CITY OF ALBUQUERQUE

April 1, 2020

**Re: Kiddie Academy Westside
Paradise/Nunzio
Traffic Circulation Layout
Architect's Stamp 03-31-2020 (C12-D003A)**

TRAFFIC CIRCULATION LAYOUT

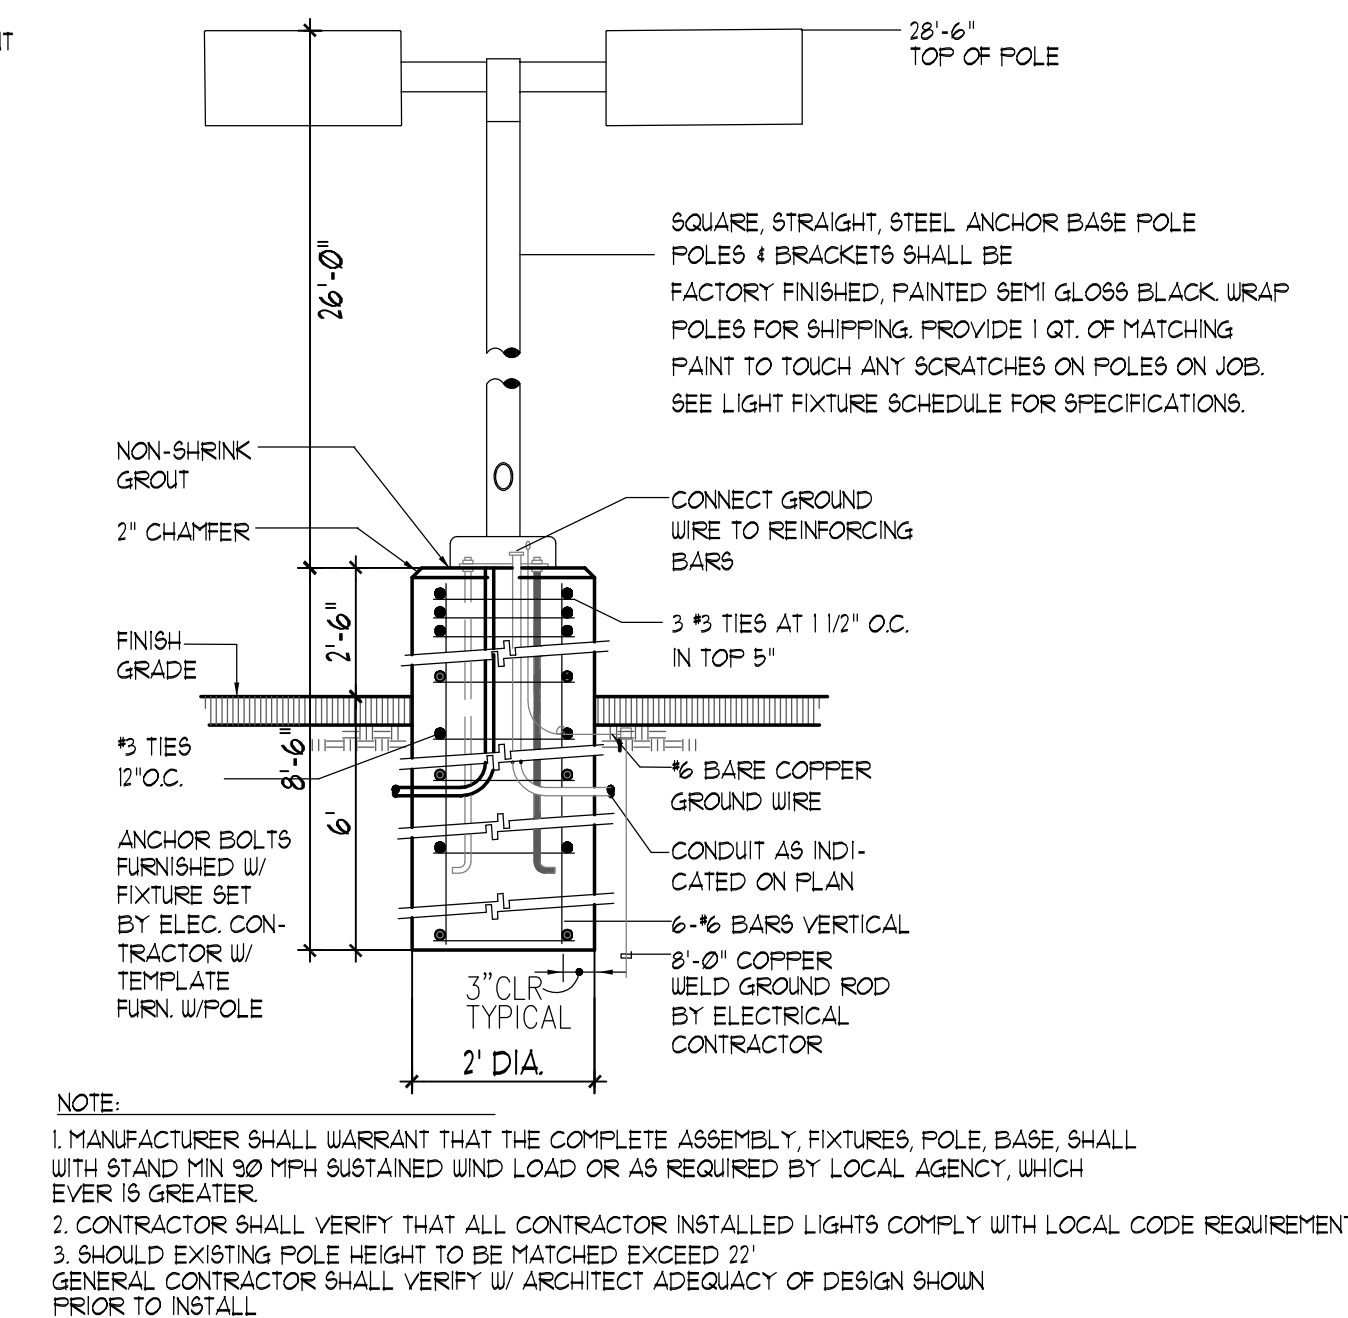
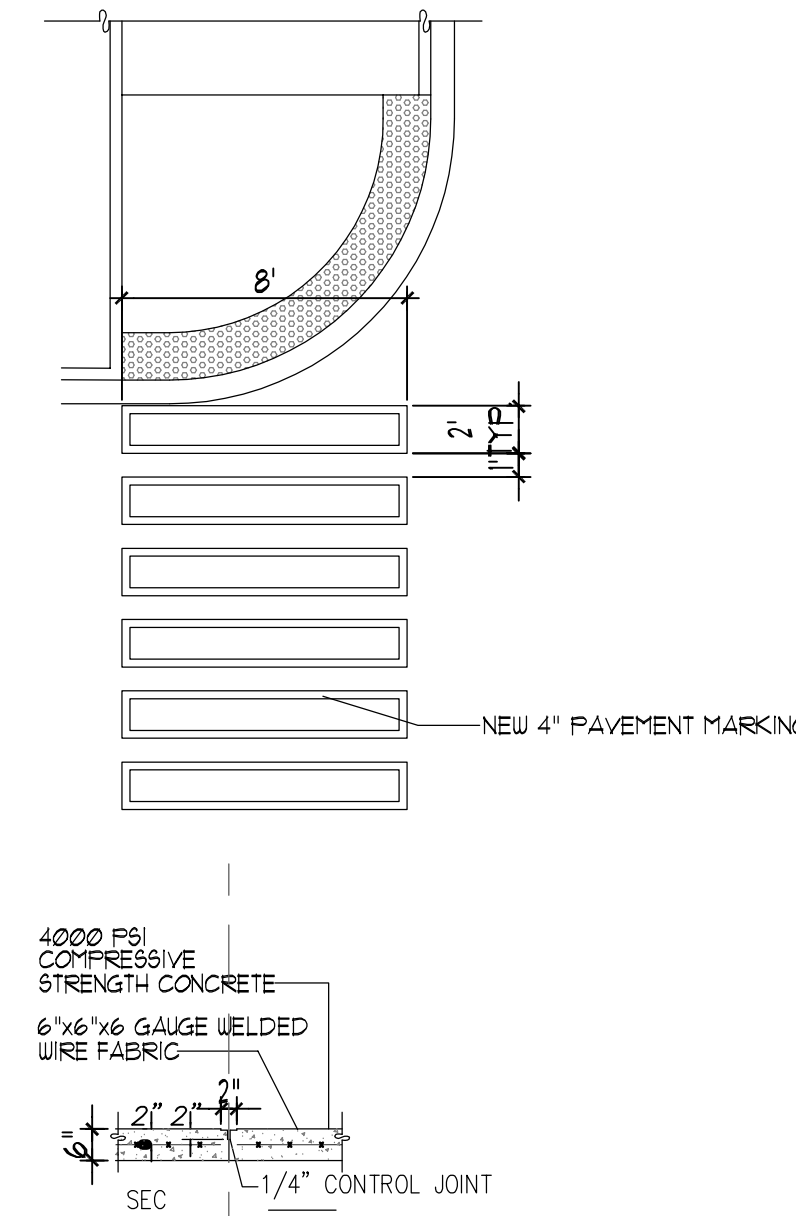
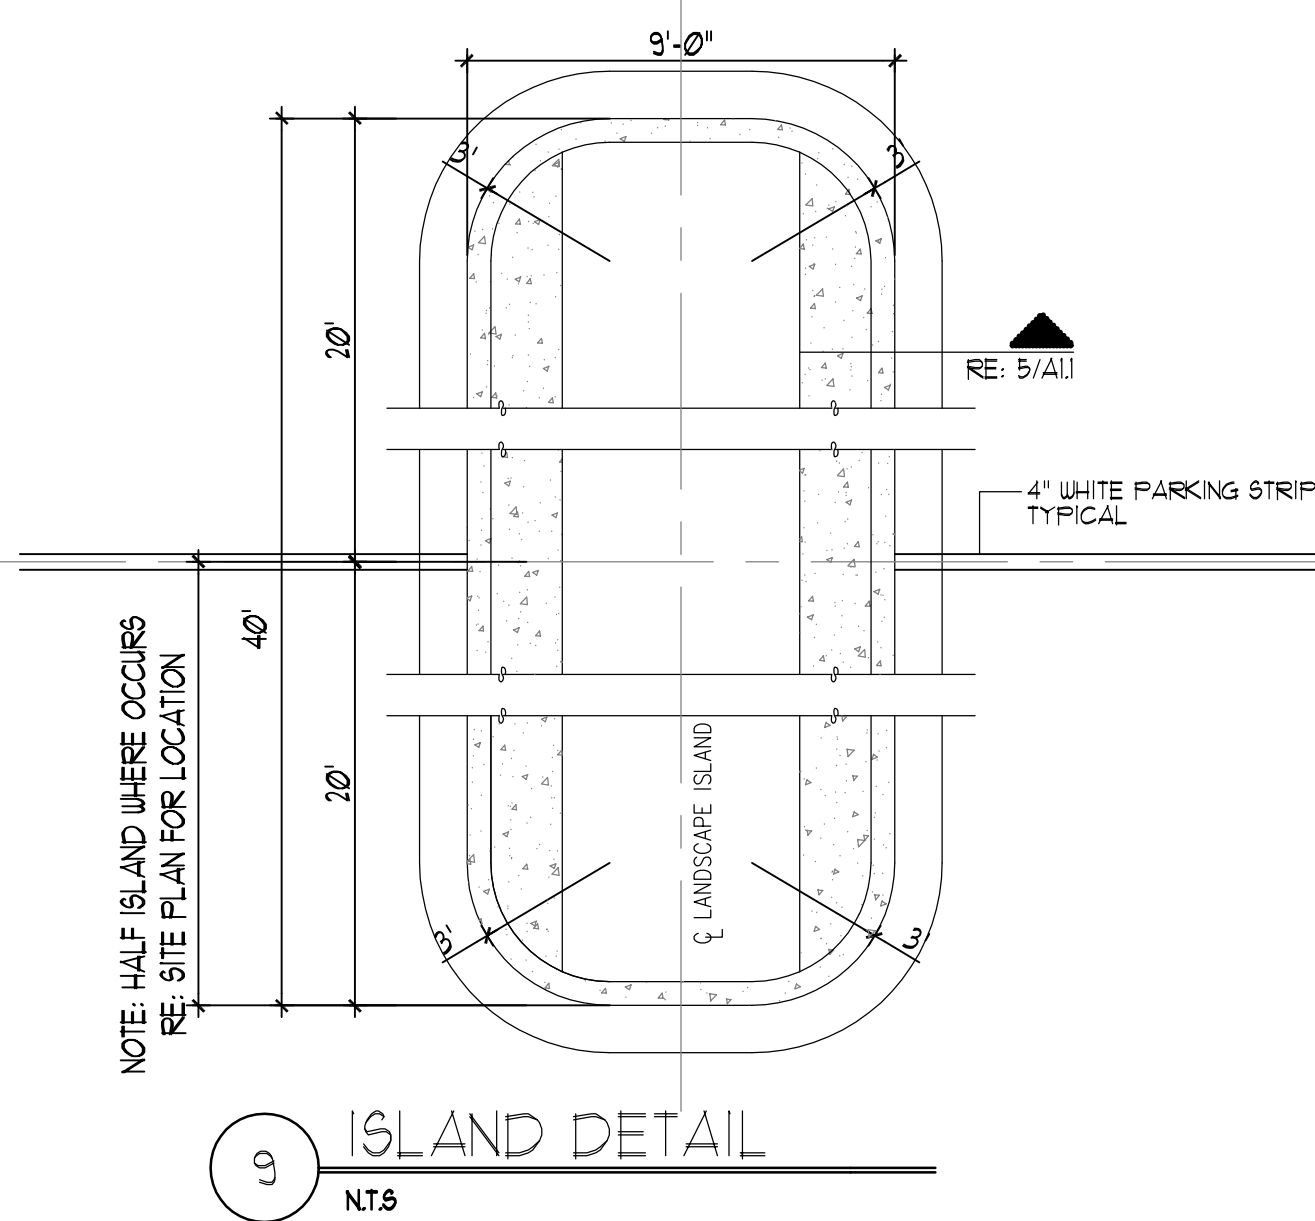
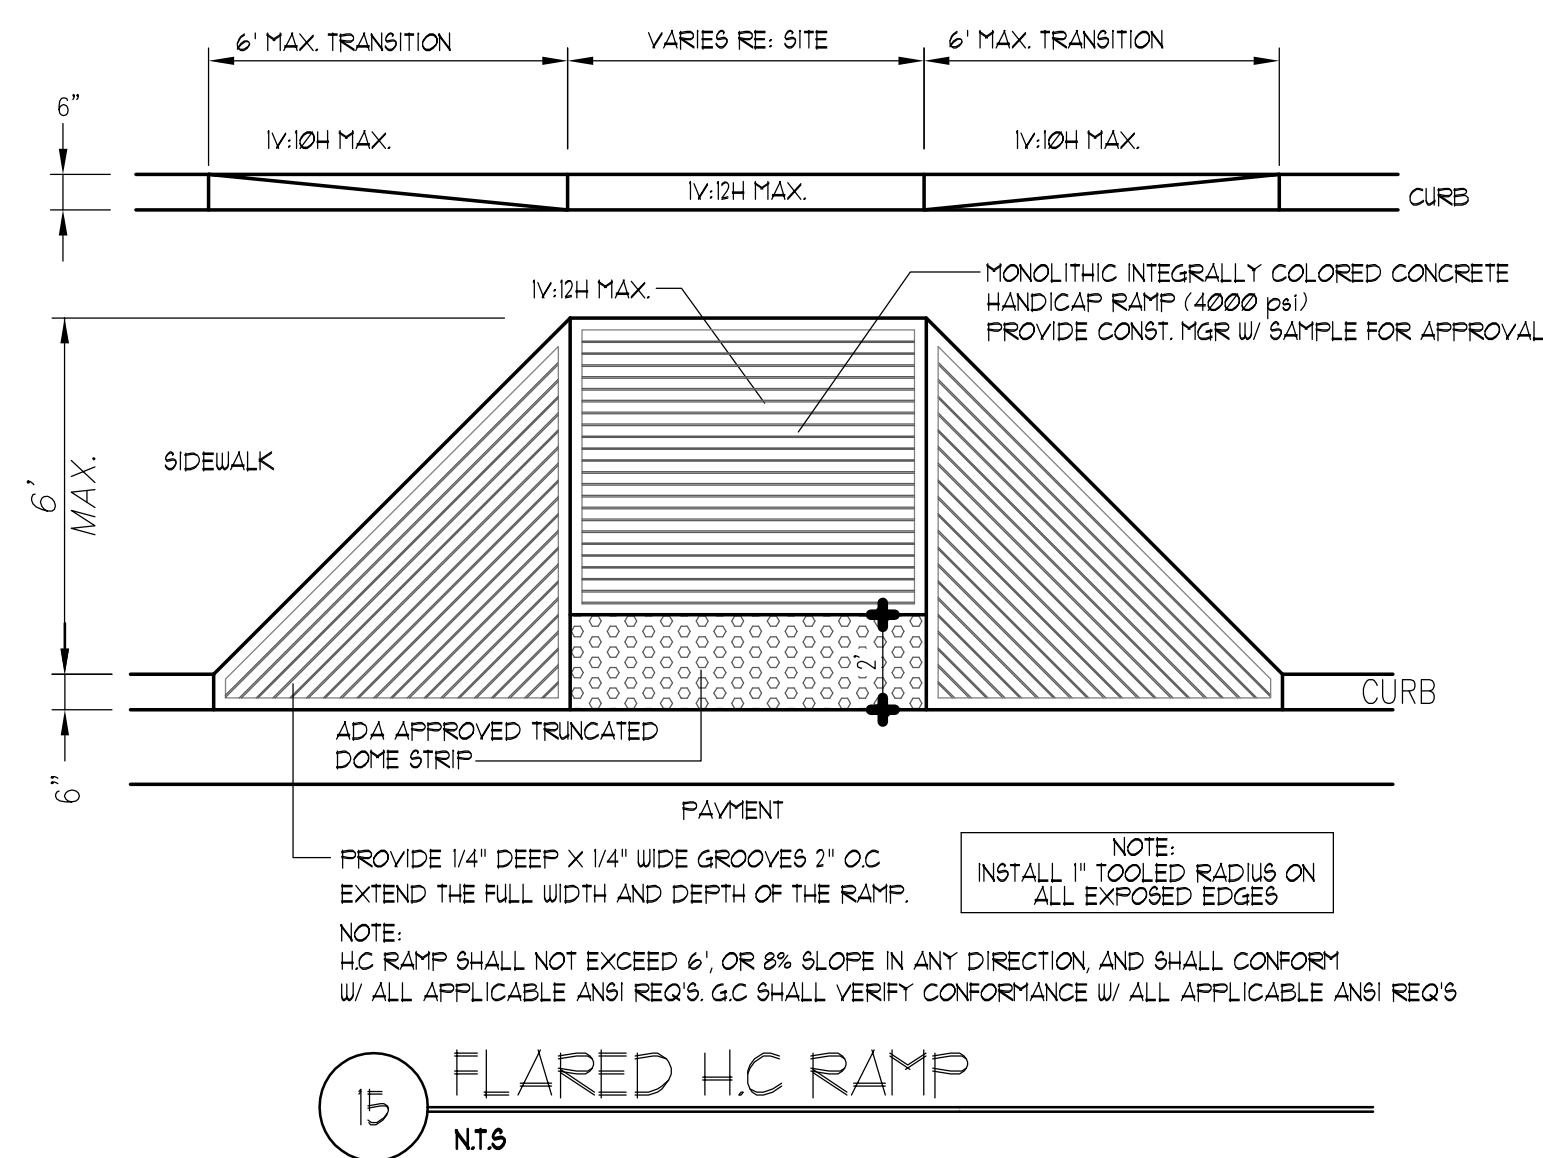
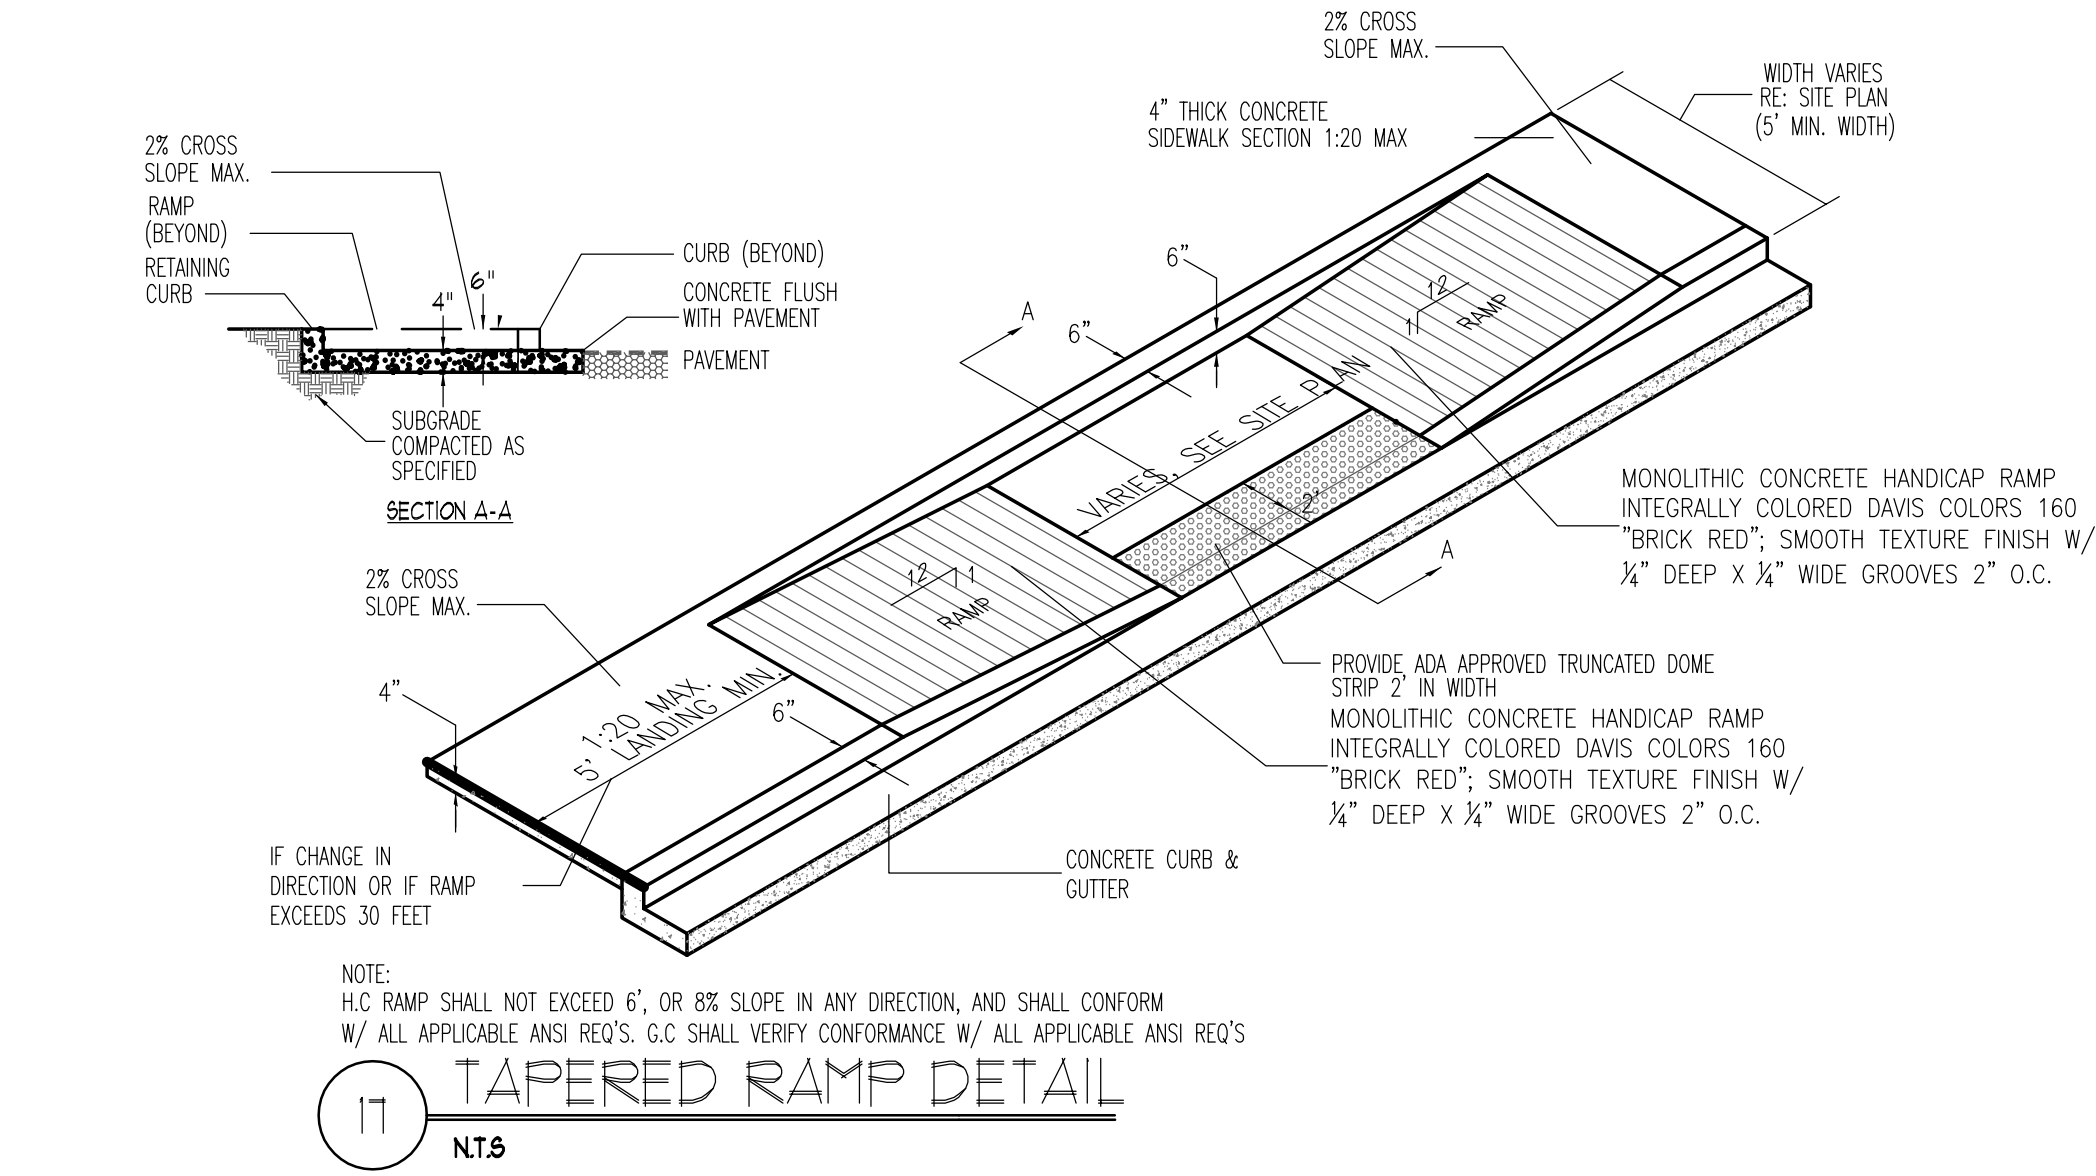
1. Please coordinate all calculations for parking spaces, including bicycle, and motorcycle parking with Zoning.
2. Clarify the extents of the current phase versus existing infrastructure off Paradise and Nunzio. Provide a phasing plan(if applicable).
3. The Paradise entrance appears to have a right and left in with a right out. Is there a access restrictions or conditions set for Paradise? Please address this issue.
4. Please label and dimension all existing infrastructure off the public streets.
5. Identify all existing access easements and rights of way width, medians, curb cuts, and street widths on Paradise and Nunzio.
6. Clarify existing property lines and proposed property lines (If applicable).
7. The minimum parking stall dimensions are:

12. Motorcycle parking spaces shall be designated by its own conspicuously posted upright sign, either free-standing or wall mounted per the zoning code. Label pavement MC.

17. The access road and parking entrances are a very small radii for all curves shown; for passenger vehicles. Radius for delivery trucks, fire trucks, etc. is 25 ft. or larger.

18. Per the IDO, a 6 ft. wide ADA accessible pedestrian pathway is required from the public sidewalk to the building entrances. Please clearly show this pathway and provide details. It appears that the sidewalk connection off Paradise entrances is in conflict with the proposed ADA ramp. Clarify this issue.

19. Per DPM, a 6 ft. wide ADA accessible pedestrian pathway is required from the ADA parking stall access aisles (ADA ramp width) to the building entrances. Please clearly show this pathway and provide details.

20. ADA accessible pedestrian pathway should not be placed behind parking space or adjacent to a vehicular way. Vehicle and pedestrian/wheel chair conflicts should be avoided as much as possible.

21. All sidewalks along streets should be dimensioned and label.

22. The Nunzio entrance has sidewalk across the acces roadway. Please clear up this issue.
23. A 6 ft. valley gutter will need to be provided at the Paradise and Nunzio entrances.

24. Curbing proposed in parking, and pedestrian ways, access roadway, and points of access will need to be called out detailed.
25. Refuse vehicle maneuvering shall be contained on-site. The refuse vehicle shall not back into the access road unless you have refuse approval. Please provide a copy of refuse approval.

26. It is not apparent what type of pavement surface is being proposed. A hard driving surface will be required as part of this proposed project for parking area and drive aisles.

27. One Way sign and symbol will be needed at median off Nunzio entrance. Please coordinate any required signage with Traffic Operations (Mahn Tran: 505-857-8689) for the type of signage and the location of the installment.

28. Please provide a sight line distance exhibit for the intersection of Paradise and Nunzio with proposed landscaping (see attachment for exhibit).
29. Show the clear sight triangle and add the following note to the plan:
"Landscaping and signage will not interfere with clear sight requirements. Therefore, signs, walls, trees, and shrubbery between 3 and 8 feet tall (as measured from the gutter pan) will not be acceptable in the clear sight triangle.

30. Please specify the City Standard Drawing Number when applicable.
31. Shared Site acces: driveways that straddle property lines, or are entirely on one property but are to be used by another property, shall have an access easement. Please include a copy of your shared access agreement with the adjacent property owner.

32. You will need written permission from adjacent landowner for proposed ADA ramp off Paradis.
33. A street address is will need to be provided for this proposed project.

34. Provide notes showing what work is included on public street versus the private work on site. The limits of the curb return for access entrances.
35. Add a note stating "All broken or cracked sidewalk must be replaced with sidewalk and curb & gutter." A build note must be provided referring to the appropriate City Standard drawing.

36. **Key Note 6** references Landscaping Plan, please remove from plans because I am not approving this part of the request.

13 BIKE RACK  
NTS

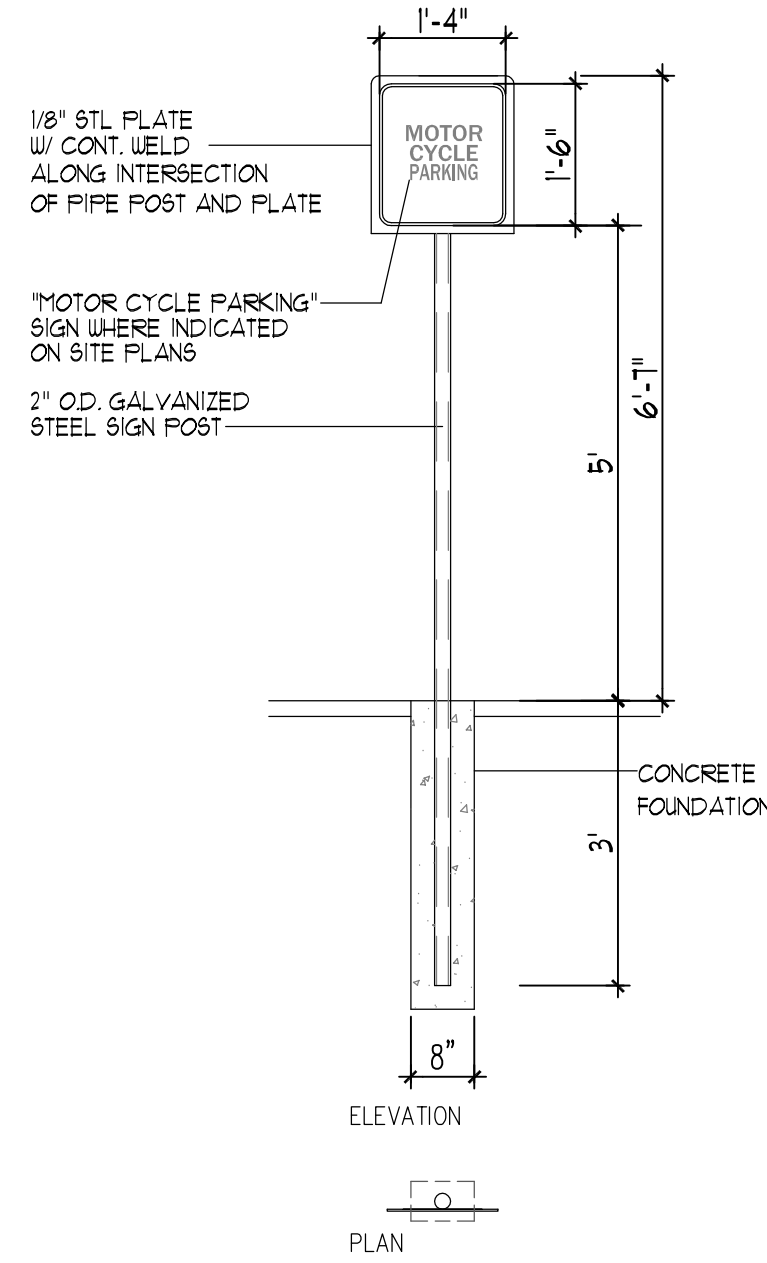
13. All bicycle racks shall be designed according to the following guidelines:
 - a. The rack shall be a minimum 30 inches tall and 18 inches wide.
 - b. The bicycle frame shall be supported horizontally at two or more places. Comb/toaster racks are not allowed.

- c. The rack shall be designed to support the bicycle in an upright position. See the IDO for additional information.
 - d. The rack allows varying bicycle frame sizes and styles to be attached.

- e. The user is not required to lift the bicycle onto the bicycle rack.
 - f. Each bicycle parking space is accessible without moving another bicycle.

14. Bicycle racks shall be sturdy and anchored to a concrete pad.
15. A 1-foot clear zone around the bicycle parking stall shall be provided.
16. Bicycle parking spaces shall be at least 6 feet long and 2 feet wide.
